CITY OF ALBUQUERQUE

**Re: Boulders Phase II
 Release of Financial Guarantee—Not Accepted,
 Stamp Dated 11/19/2013
 Engineer's Stamp Date 10/24/2012 (B11/D001C)**

### THE BOULDERS PHASE 2 GRADING AND DRAINAGE PLAN

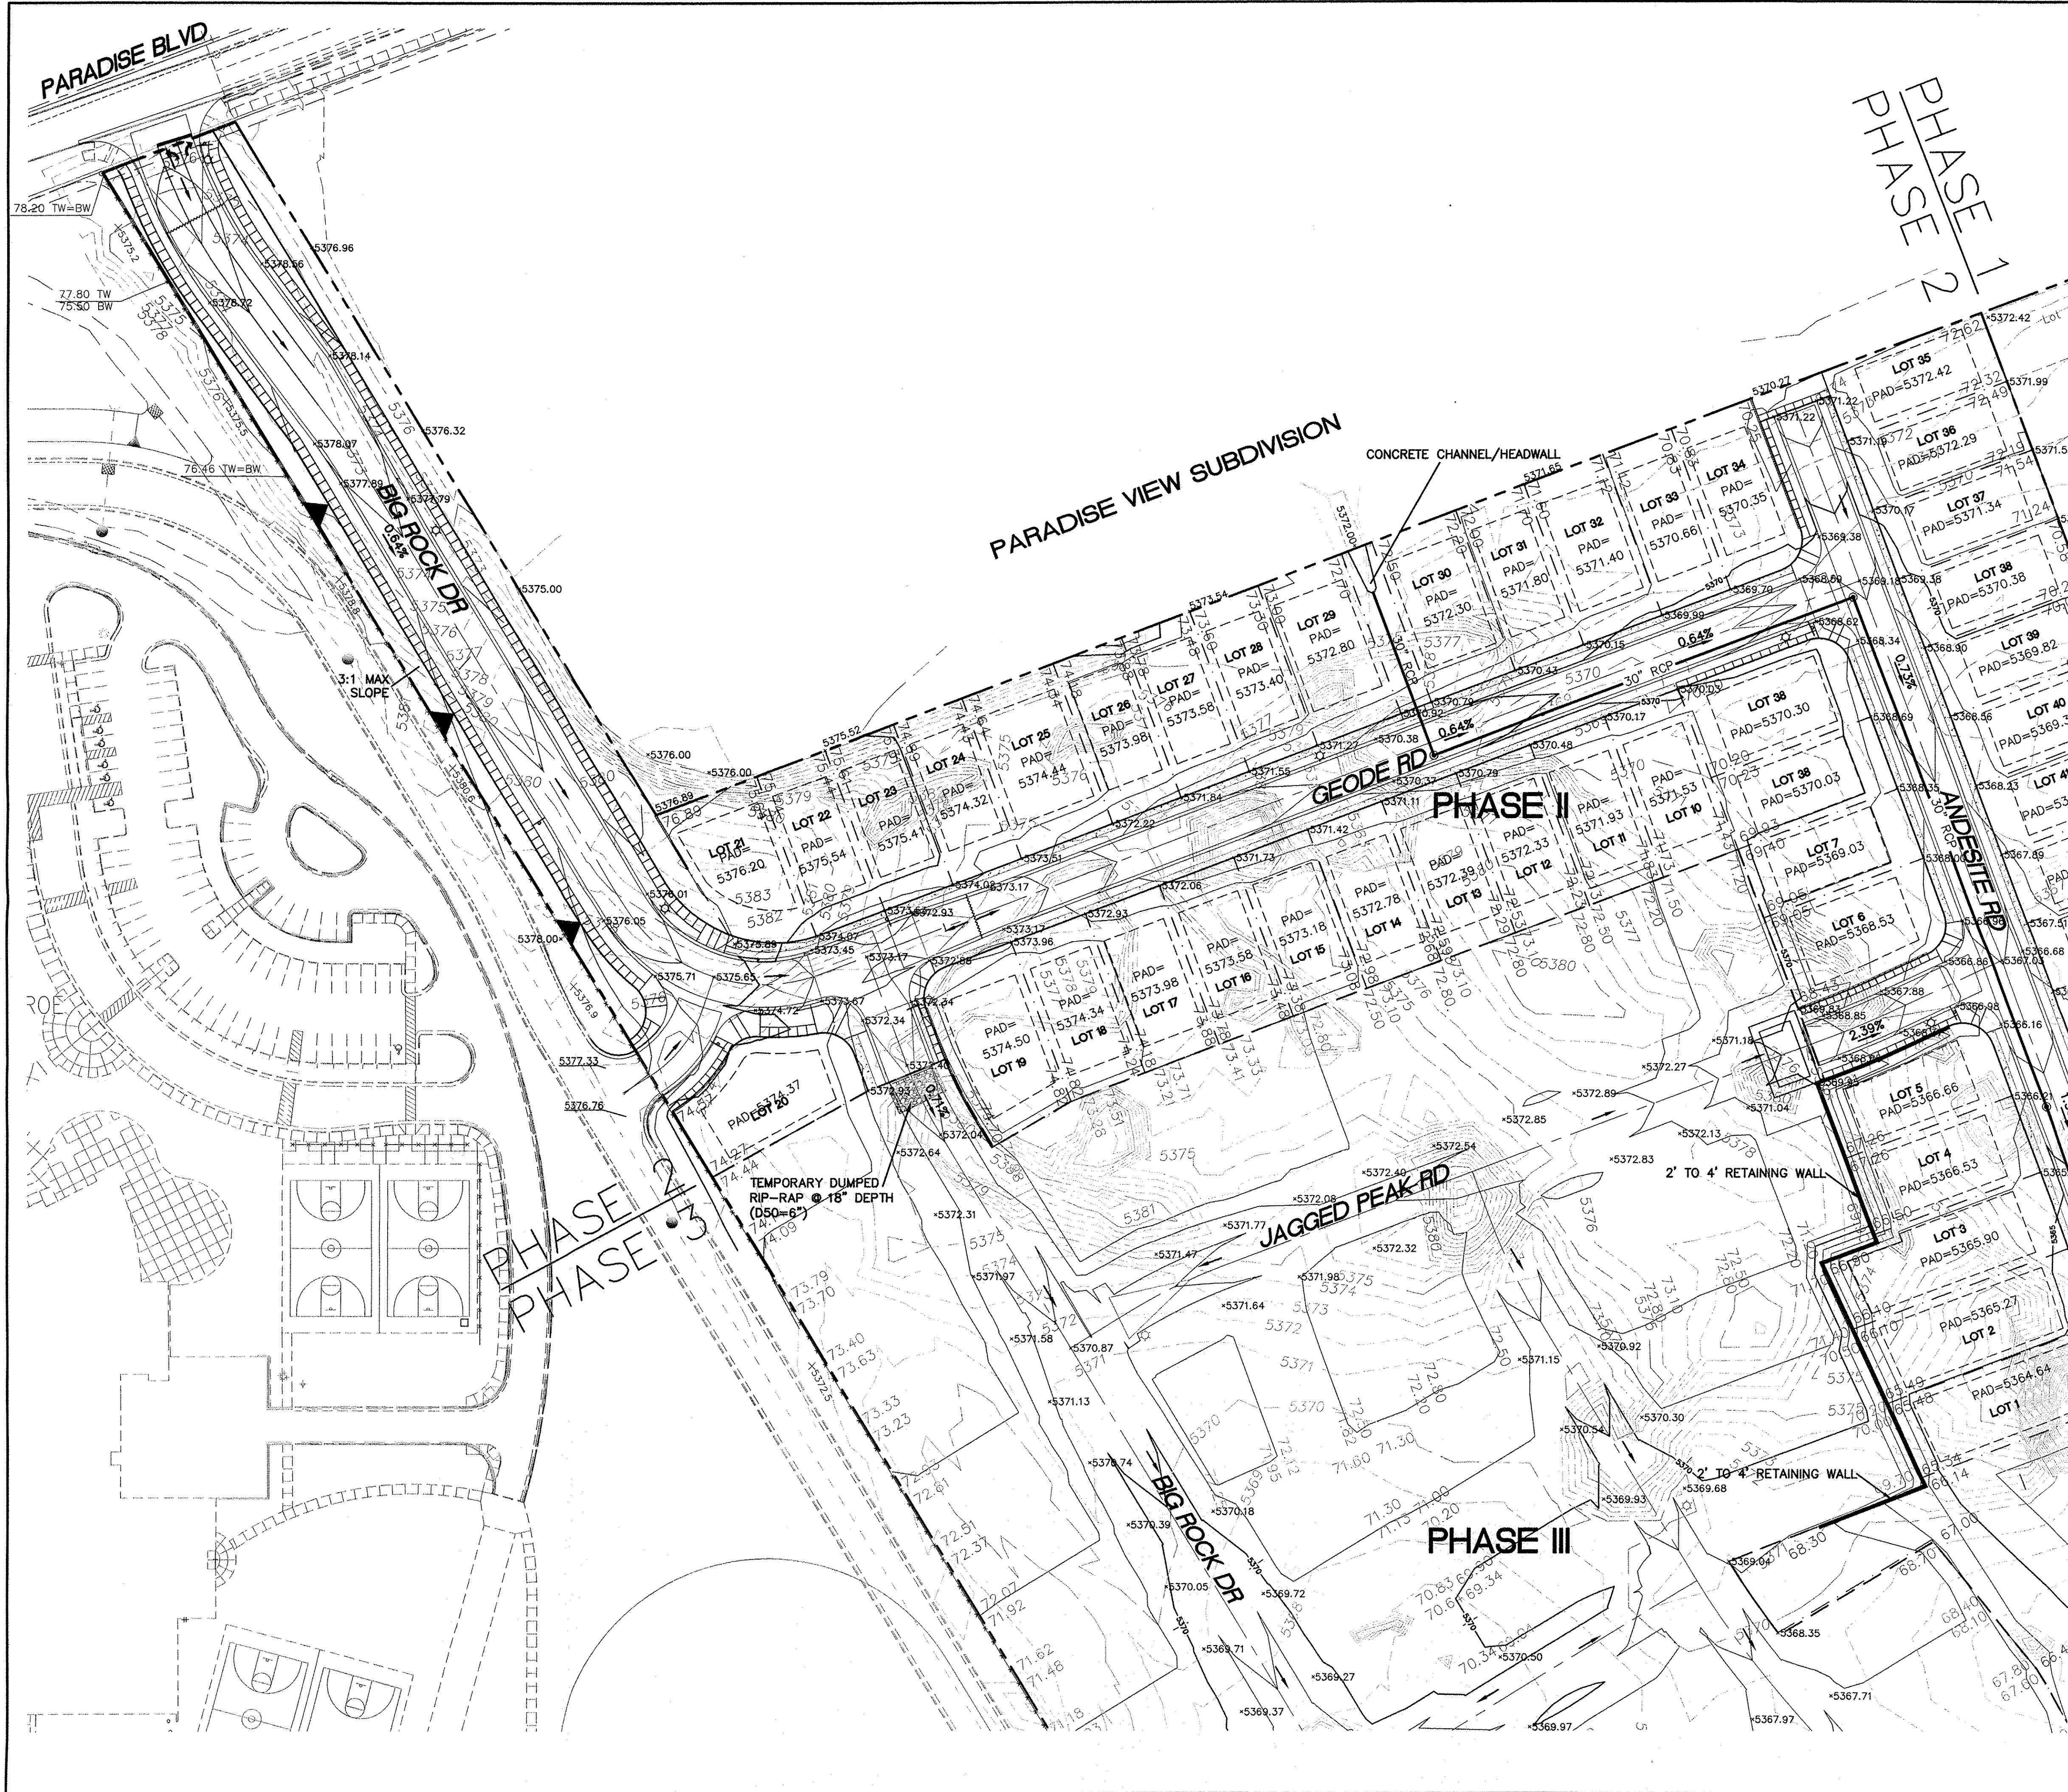
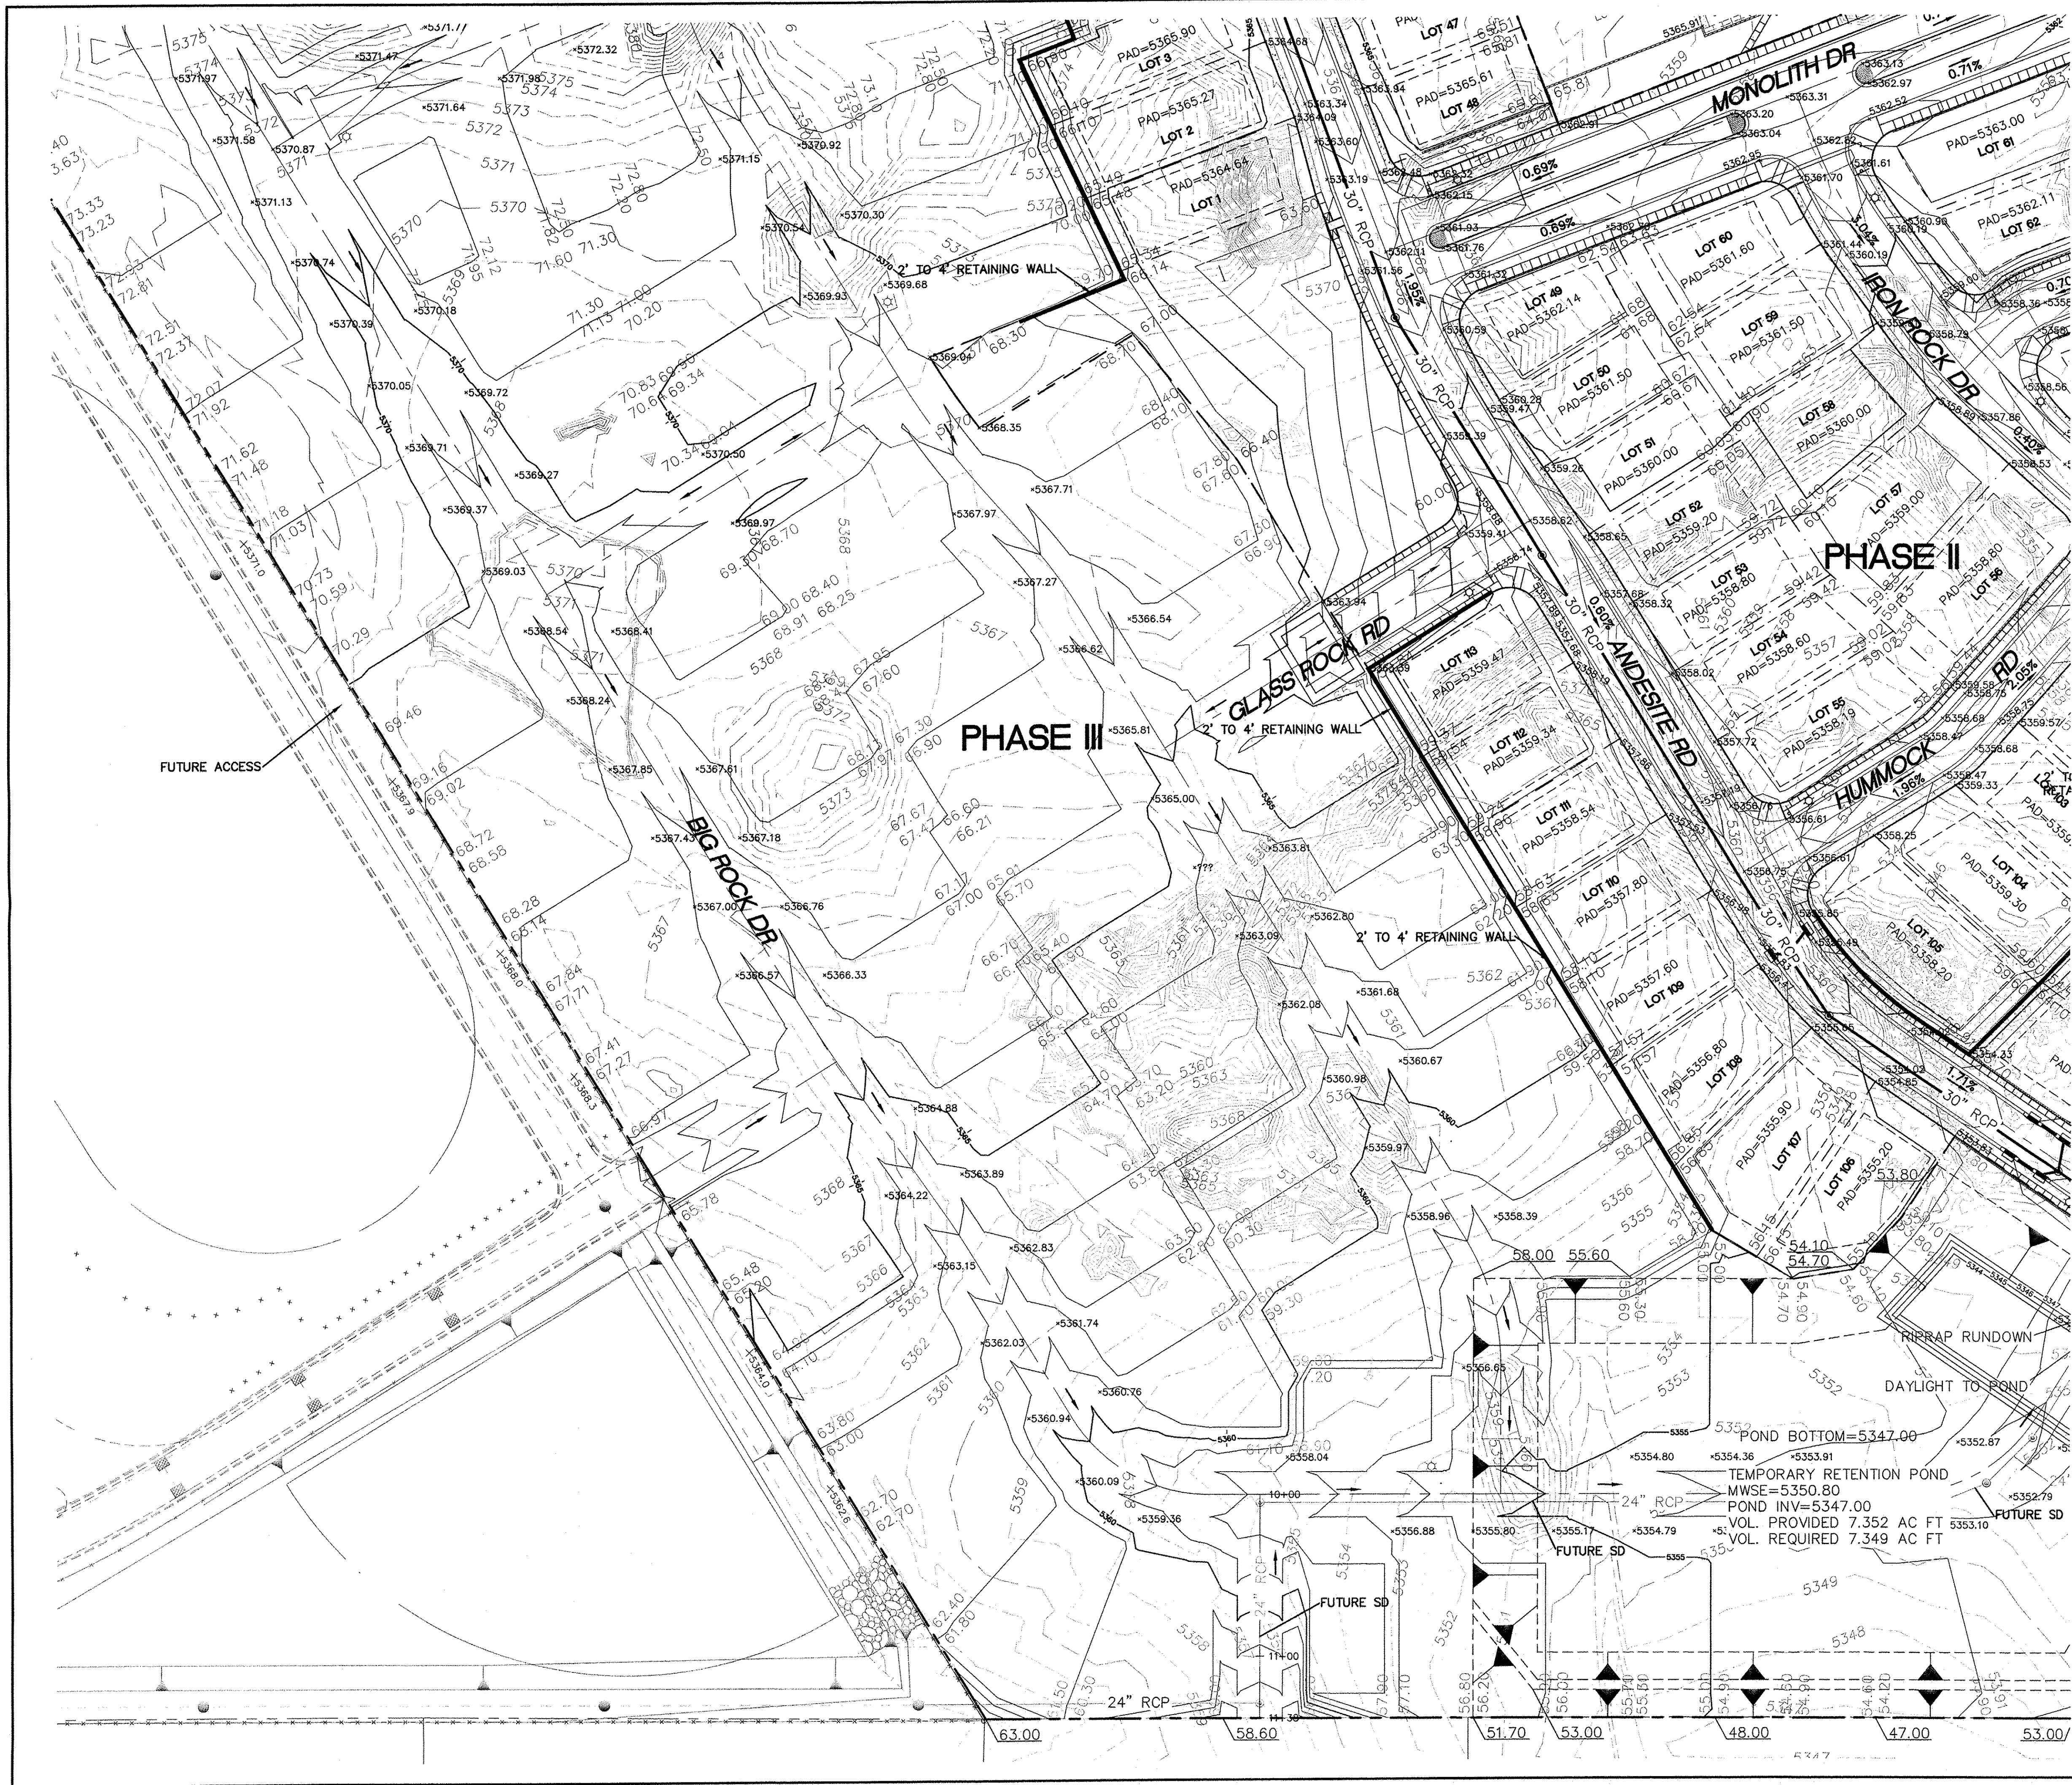
Please provide the pad grades on the DRB approved grading and drainage plan.
